## **Development Facilitation Team (DFT) – Review Comments**

**DRB Project No: PR-2021-005482 Date: 04-12-2023 Agenda Item: 5 Zone Atlas Page: M-15**

**Location: 2040 Gibson Blvd between YALE BLVD and MILES RD**

### **Application For: SD-2023-00083 – PRELIMINARY/FINAL PLAT (DHO) Sketch Plat 2-1-23 (DFT)**

**PLAT OF**  
**LOTS C-1 AND C-2**  
**LOVELACE HEIGHTS ADDITION**  
 (BEING A REPLAT OF LOT C, LOVELACE HEIGHTS ADDITION)  
 WITHIN  
**SECTION 33, TOWNSHIP 10 NORTH, RANGE 3 EAST**  
**NEW MEXICO PRINCIPAL MERIDIAN**  
**CITY OF ALBUQUERQUE**  
**BERNALILLO COUNTY, NEW MEXICO**  
 FEBRUARY, 2023

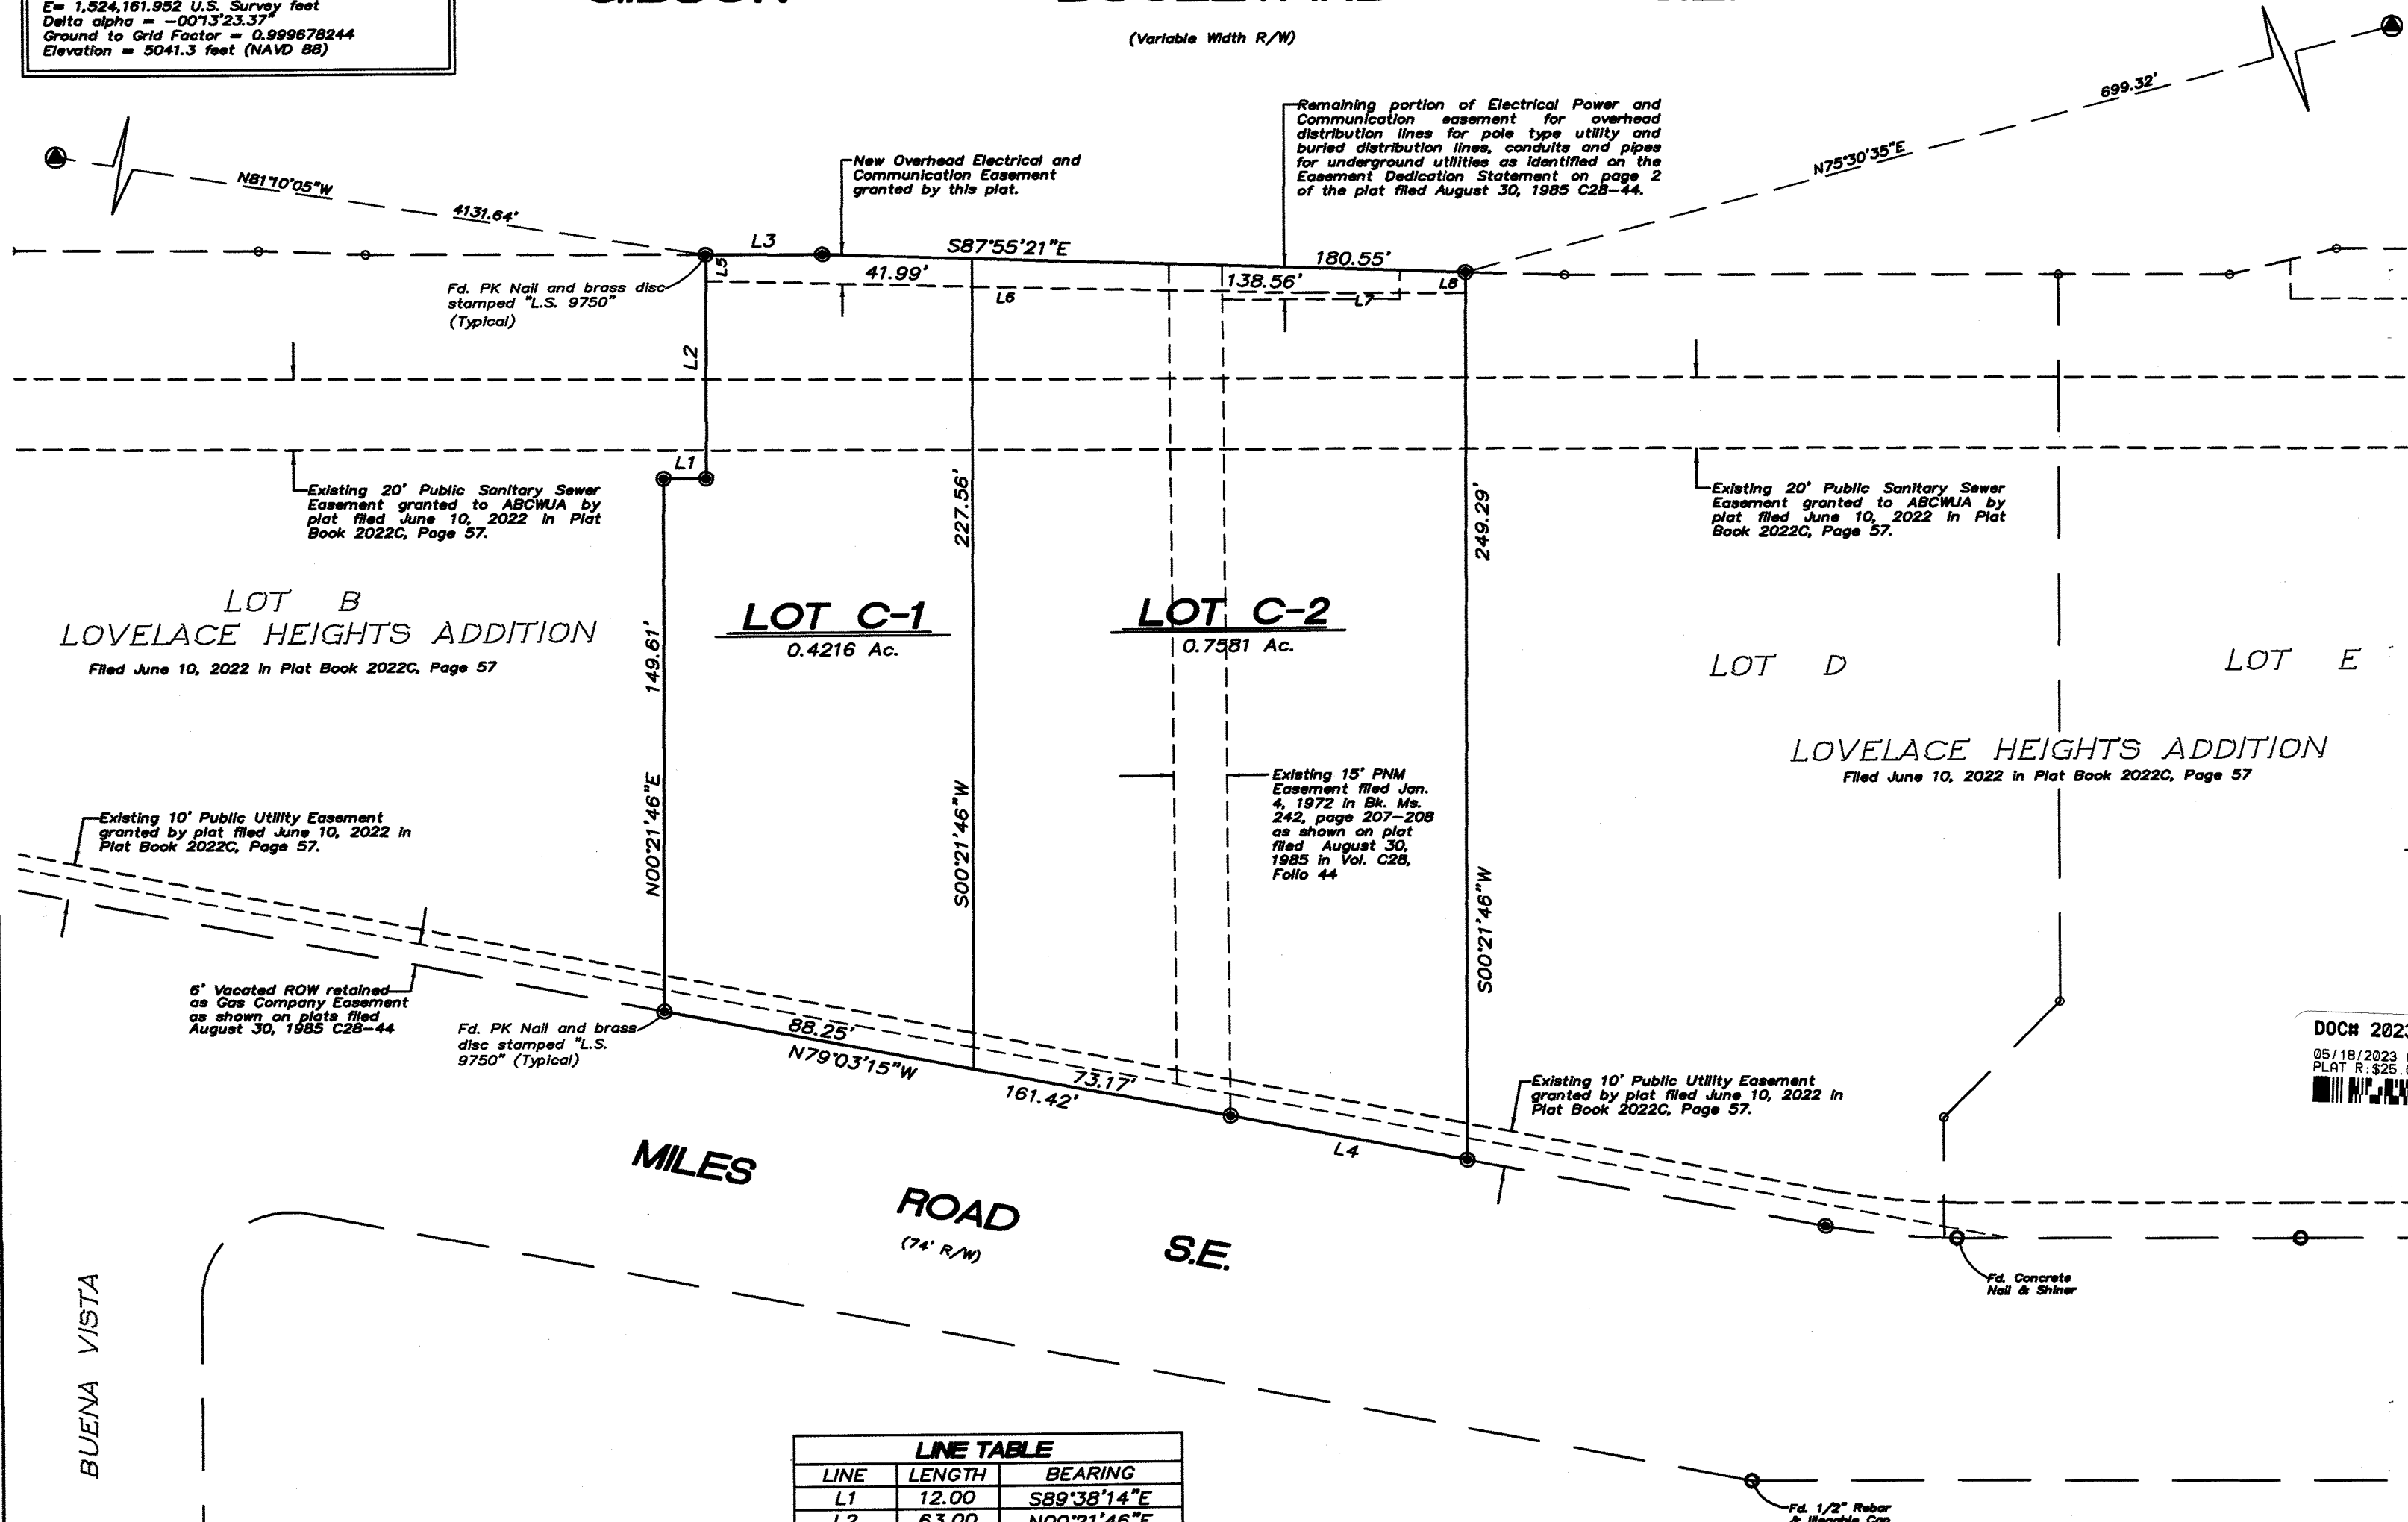
1. Please provide a cross-lot access easement for all lots on the plat.
2. An approved TCL will be required prior to site plan.

- Clarify the location of lot lines for new Tracts C vis a vis the Area of Change/Consistency line. Will the re-plat affect how development can meet the screen/buffering requirements of 5-6(E)(5) Area of Change Next to Area of Consistency?

- Obtain DXF approval from AGIS.
- Add project PR 2021-005482 and application number SD 2023-00083 to the Plat.
